An
Coimisiún
Pleanála

Direction
ABP-321734-25

WHEREAS a question has arisen as to whether renovation of an existing dwelling, the demolition of 37m² of domestic extensions to the rear of dwelling, demolition of water tank and shed (combined 10.48m²) to the side of dwelling, and construction of 40.3m² extension to the rear is or is not development or is or is not exempted development:

1
-
GROUND FLOOR PLAN - PROPOSED
1:100

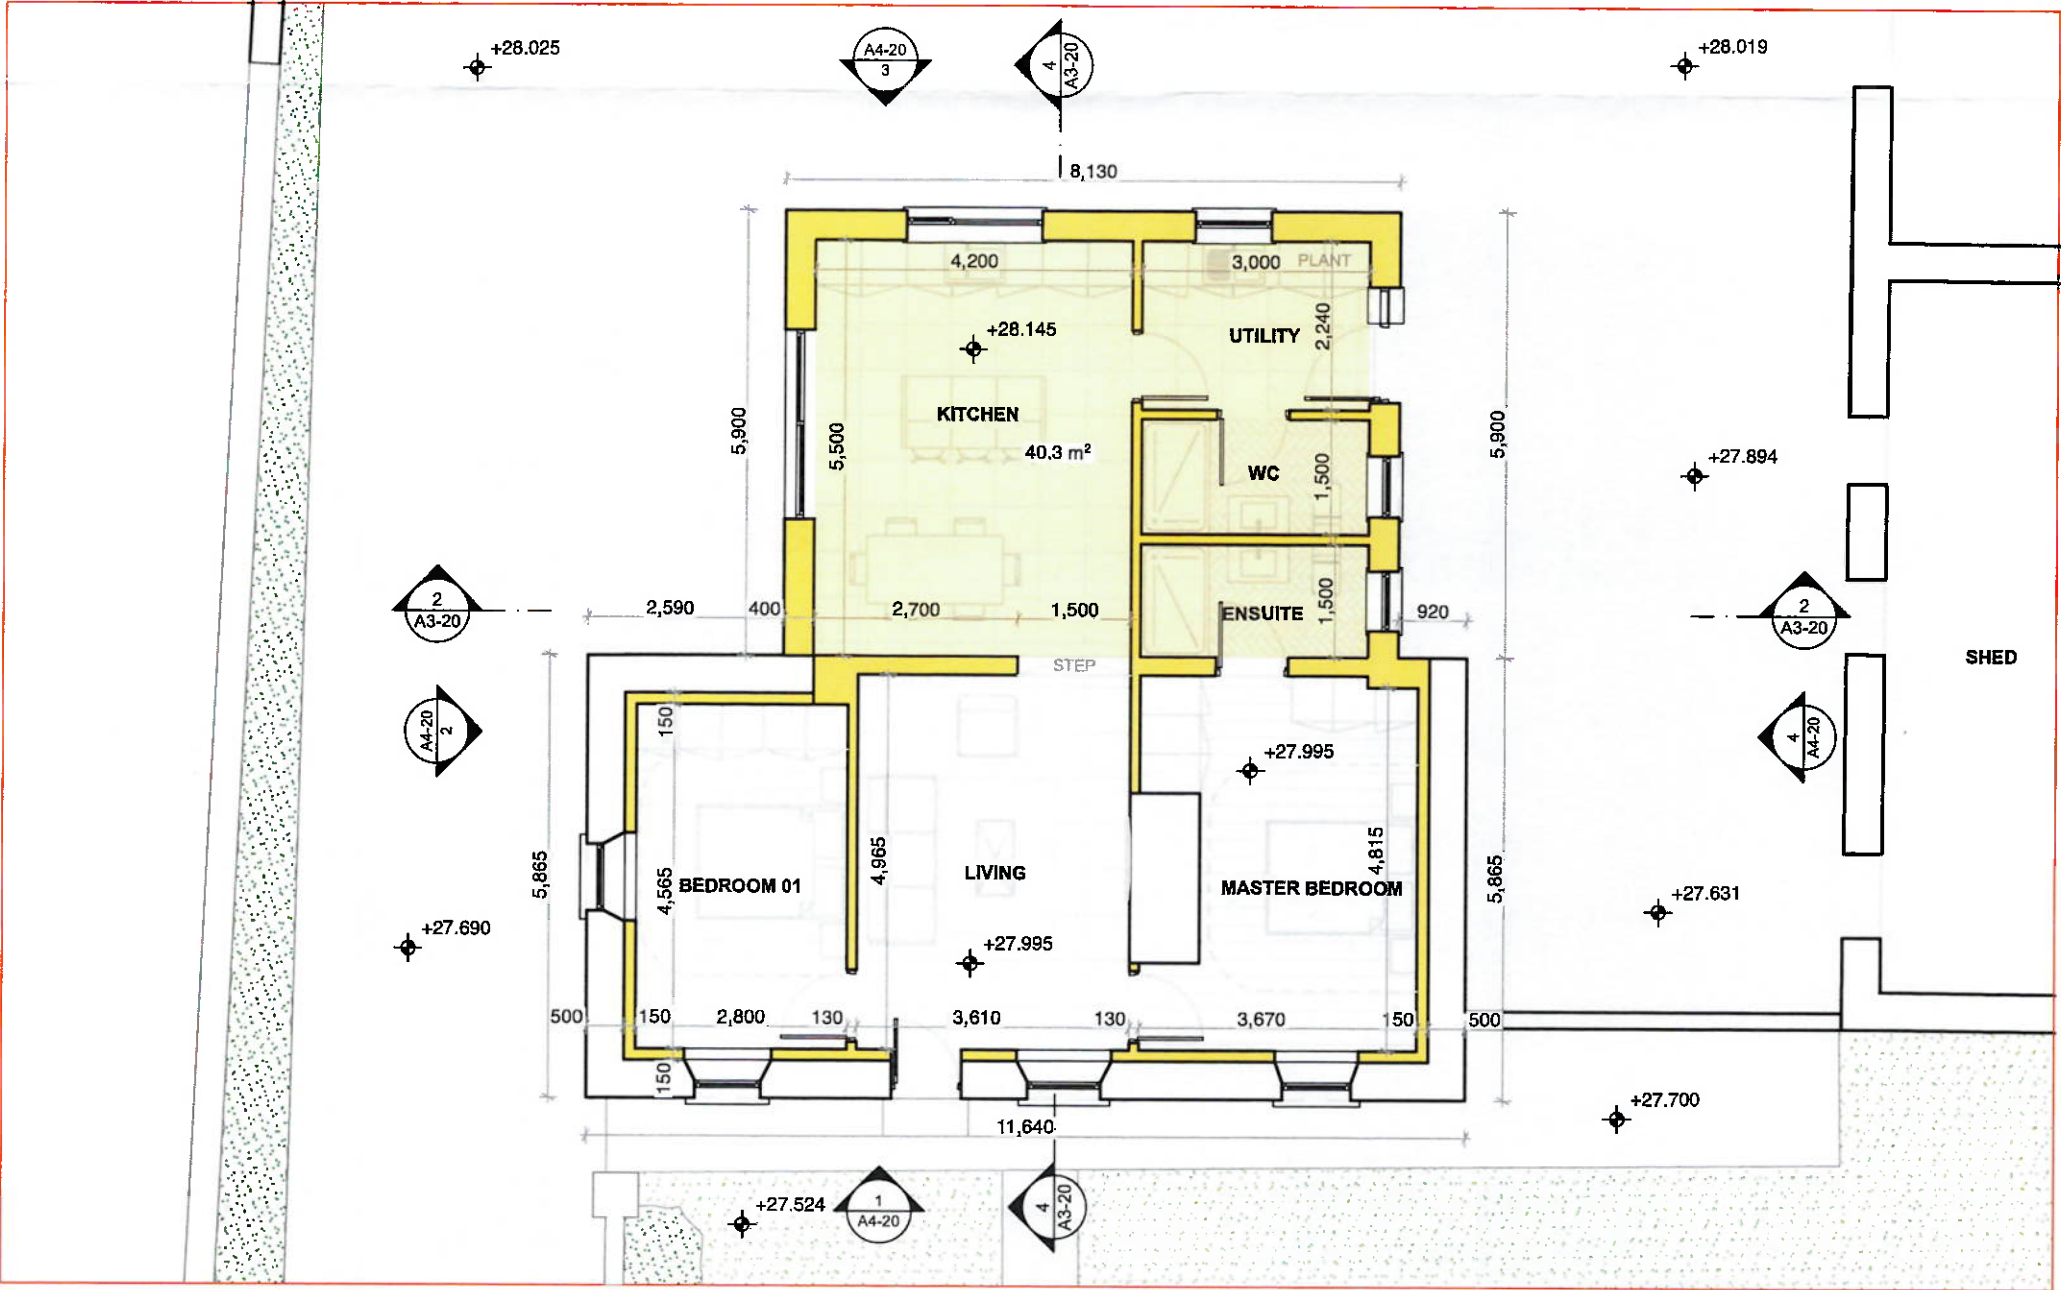
- (f) the proposed extension comes within the scope of Class 1 of Part 1 of Schedule 2 to the Planning and Development Regulations 2001 but does not meet the conditions and limits set out in Column 2 as it would exceed 40m² floorspace (specifically, it would not meet Condition and Limitation No. 1(a) of said Class as the floor area exceeds the limit by 0.3 sq.m.);

(b) the demolition of 37m² of domestic extensions to the rear of dwelling and construction of 40.3m² extension to the rear is development and is not exempted development.
